Medworth Energy from Waste Combined Heat and Power Facility – Written Summaries of Oral Representations Made by CCC and FDC at Issue Specific Hearing 6 and Issue Specific Hearing 7

Table 1.1 – Written Summaries of Oral Representations Made at ISH6 on Monday 26 June 2023

**Figure 3.19i**  
**New Bridge Lane access proposal**

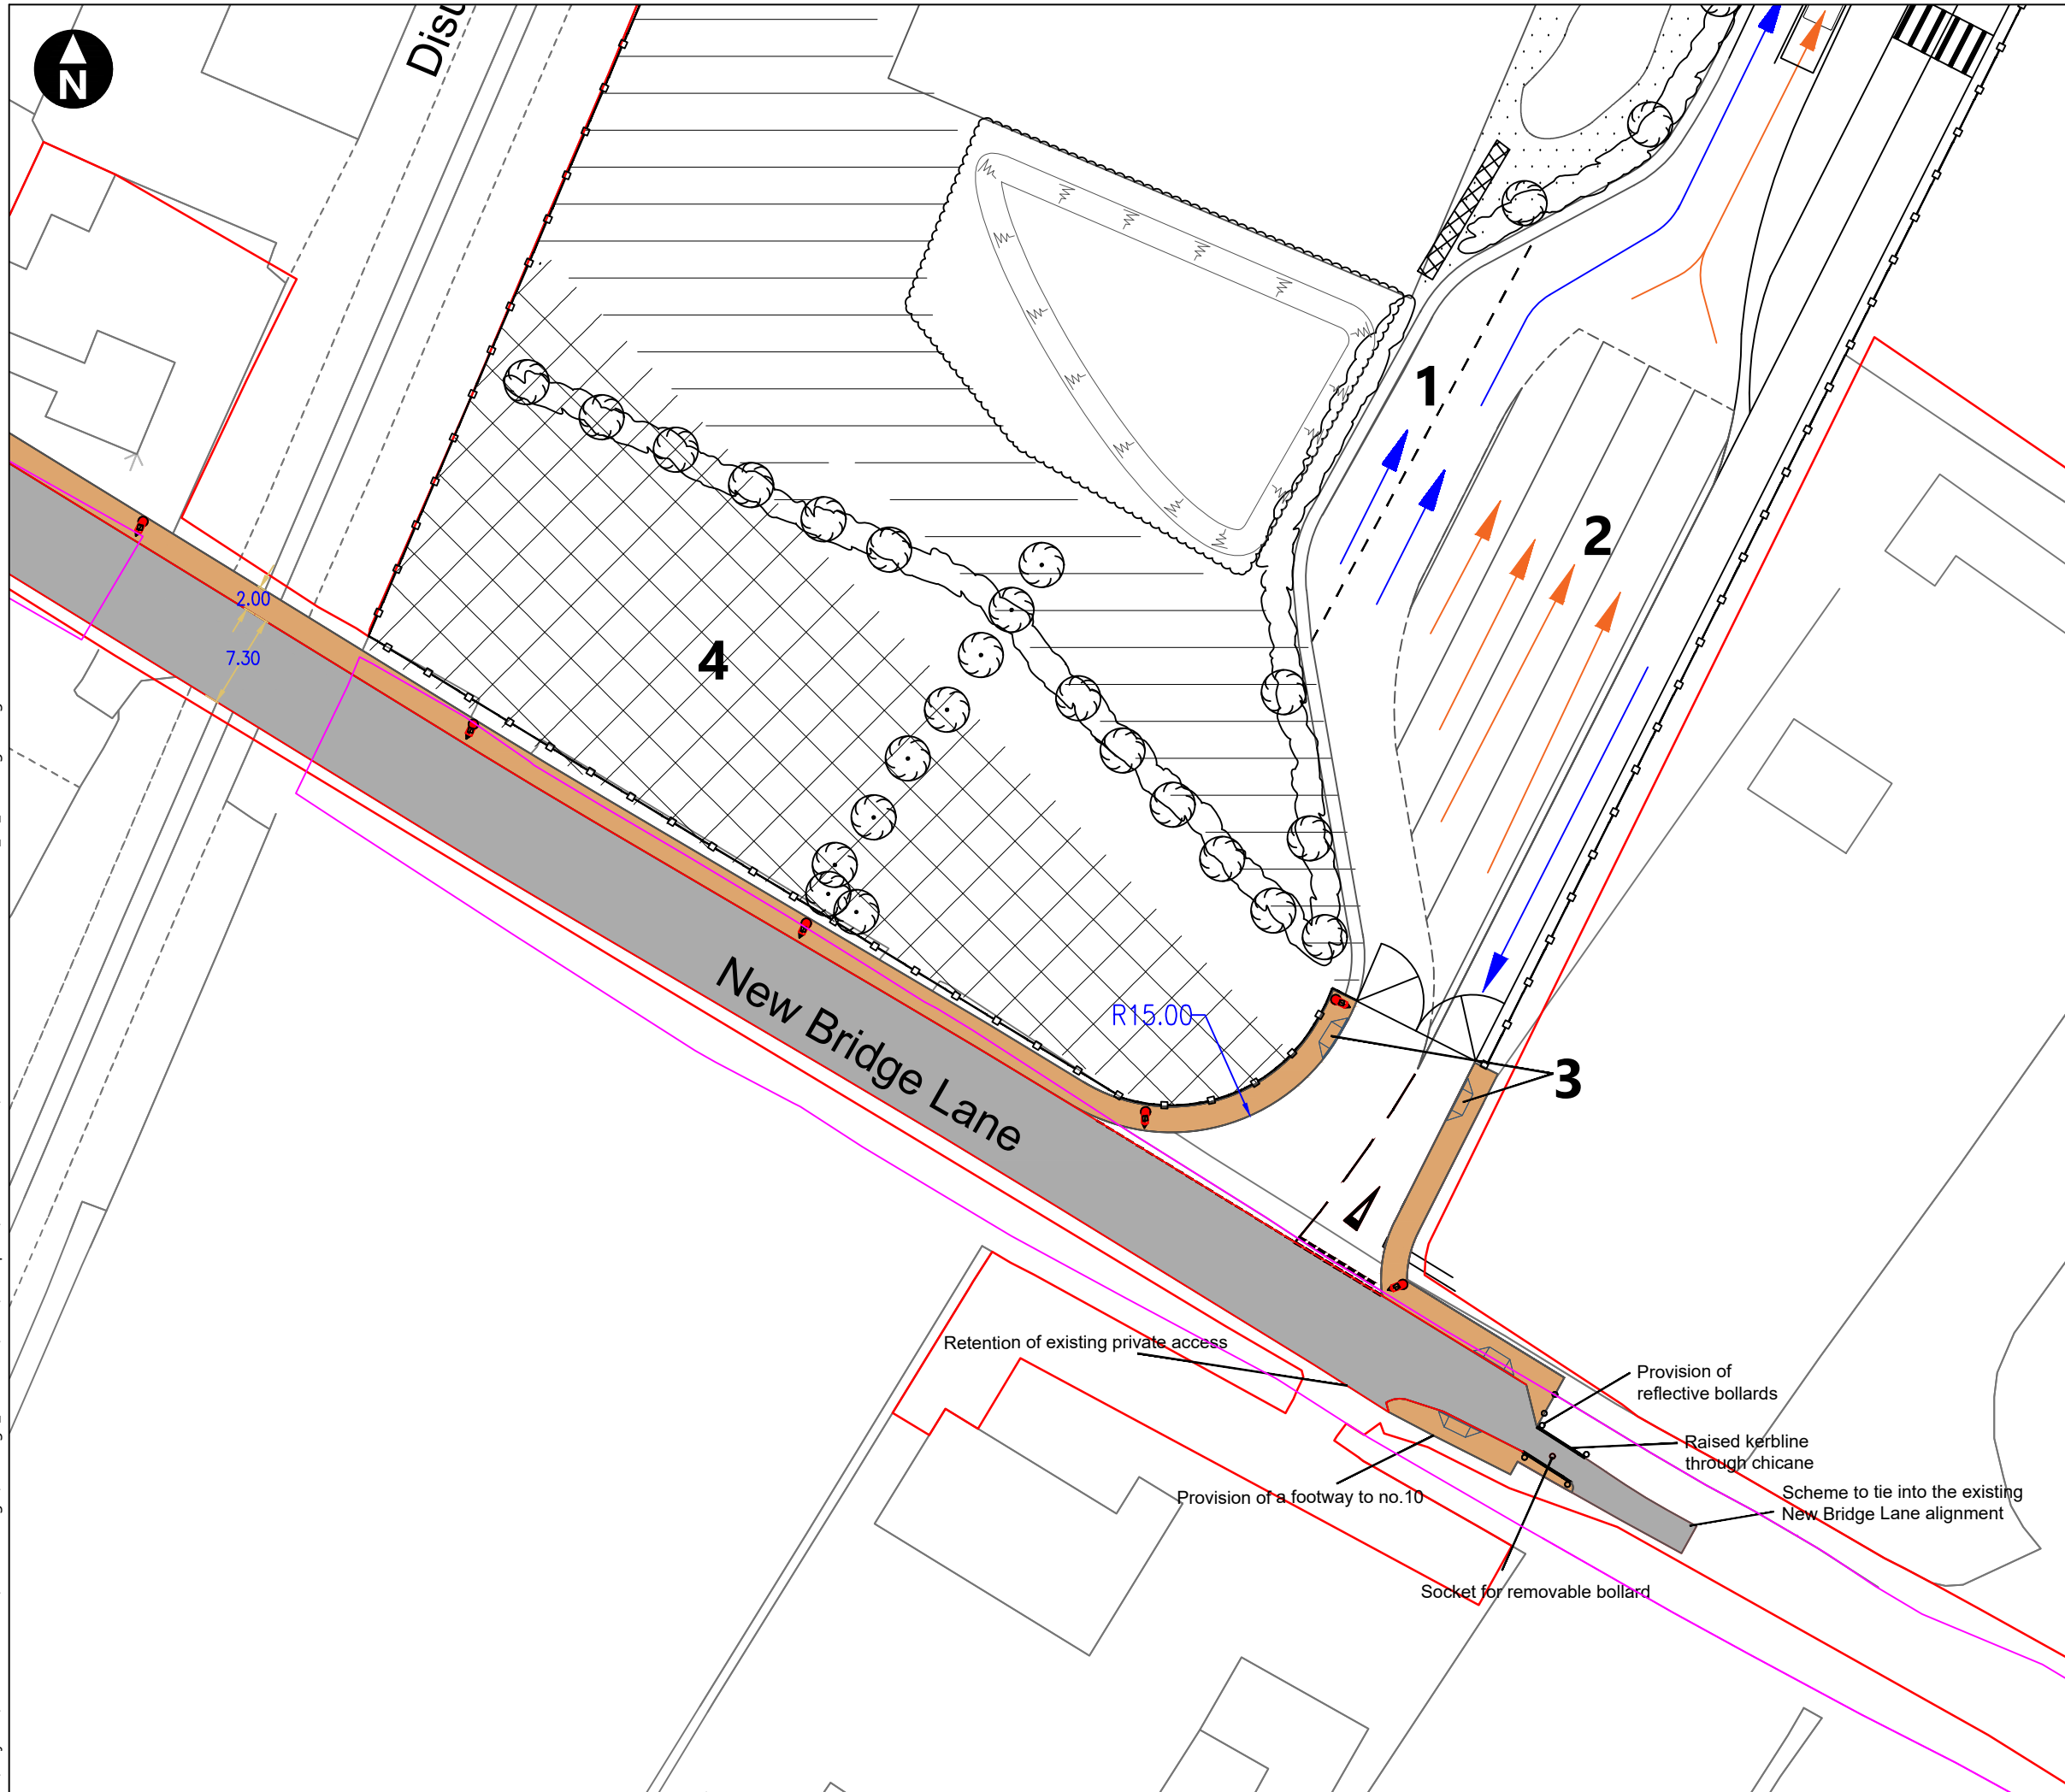
assumptions, they are concerned with some of the signal phasing, as it appears to allow right turn traffic from the South onto New Bridge Lane without stopping the southbound traffic from the north. This would allow the southbound traffic to cut across the northbound traffic's right turn. The Councils feel the southbound traffic would need to be stopped in all settings to allow the northbound traffic to turn right onto New Bridge Lane. The phasing diagrams submitted by the Applicant show the southbound traffic is not stopped in all settings currently. The staging needs to be completely separate so that the southbound from Wisbech traffic is stopped to allow the vehicles turning right into New Bridge Lane to do so safely.

Mr Daniel Ashman, Asset Information Searches Manager, then explained that the Councils question whether the plans include sufficient land for the required improvements to the New Bridge Lane/Cromwell Road junction. Firstly, the additional land required by the Applicant on the carriageways of both New Bridge Lane and Cromwell Road does not achieve a sufficient distance back from the proposed stop lines that would be installed at the revised junction. A minimum distance of 50m is required, to ensure appropriate road surfaces and sensors can be installed, at the correct locations of the junction. This should be included within the expanded DCO boundary.

Second, on the western side of the crossroads, on the land that borders the Murkett's car garage, the DCO boundary has been expanded slightly but there appears to be limited space in one area.

Mr Fraser-Urquhart KC asked Mr Tuttle to confirm whether there was any technical or practical reason why this could not be done. Mr Richard Ling Traffic Signals and Systems Manager confirmed that there is no reason why the staging cannot be changed and remodelled to show the manoeuvre safely.

Mr Tuttle confirmed that there may be some sensitivity testing required in the modelling of the junction, but that the Council are happy to proceed with the Applicant to resolve the technical junction design issues.
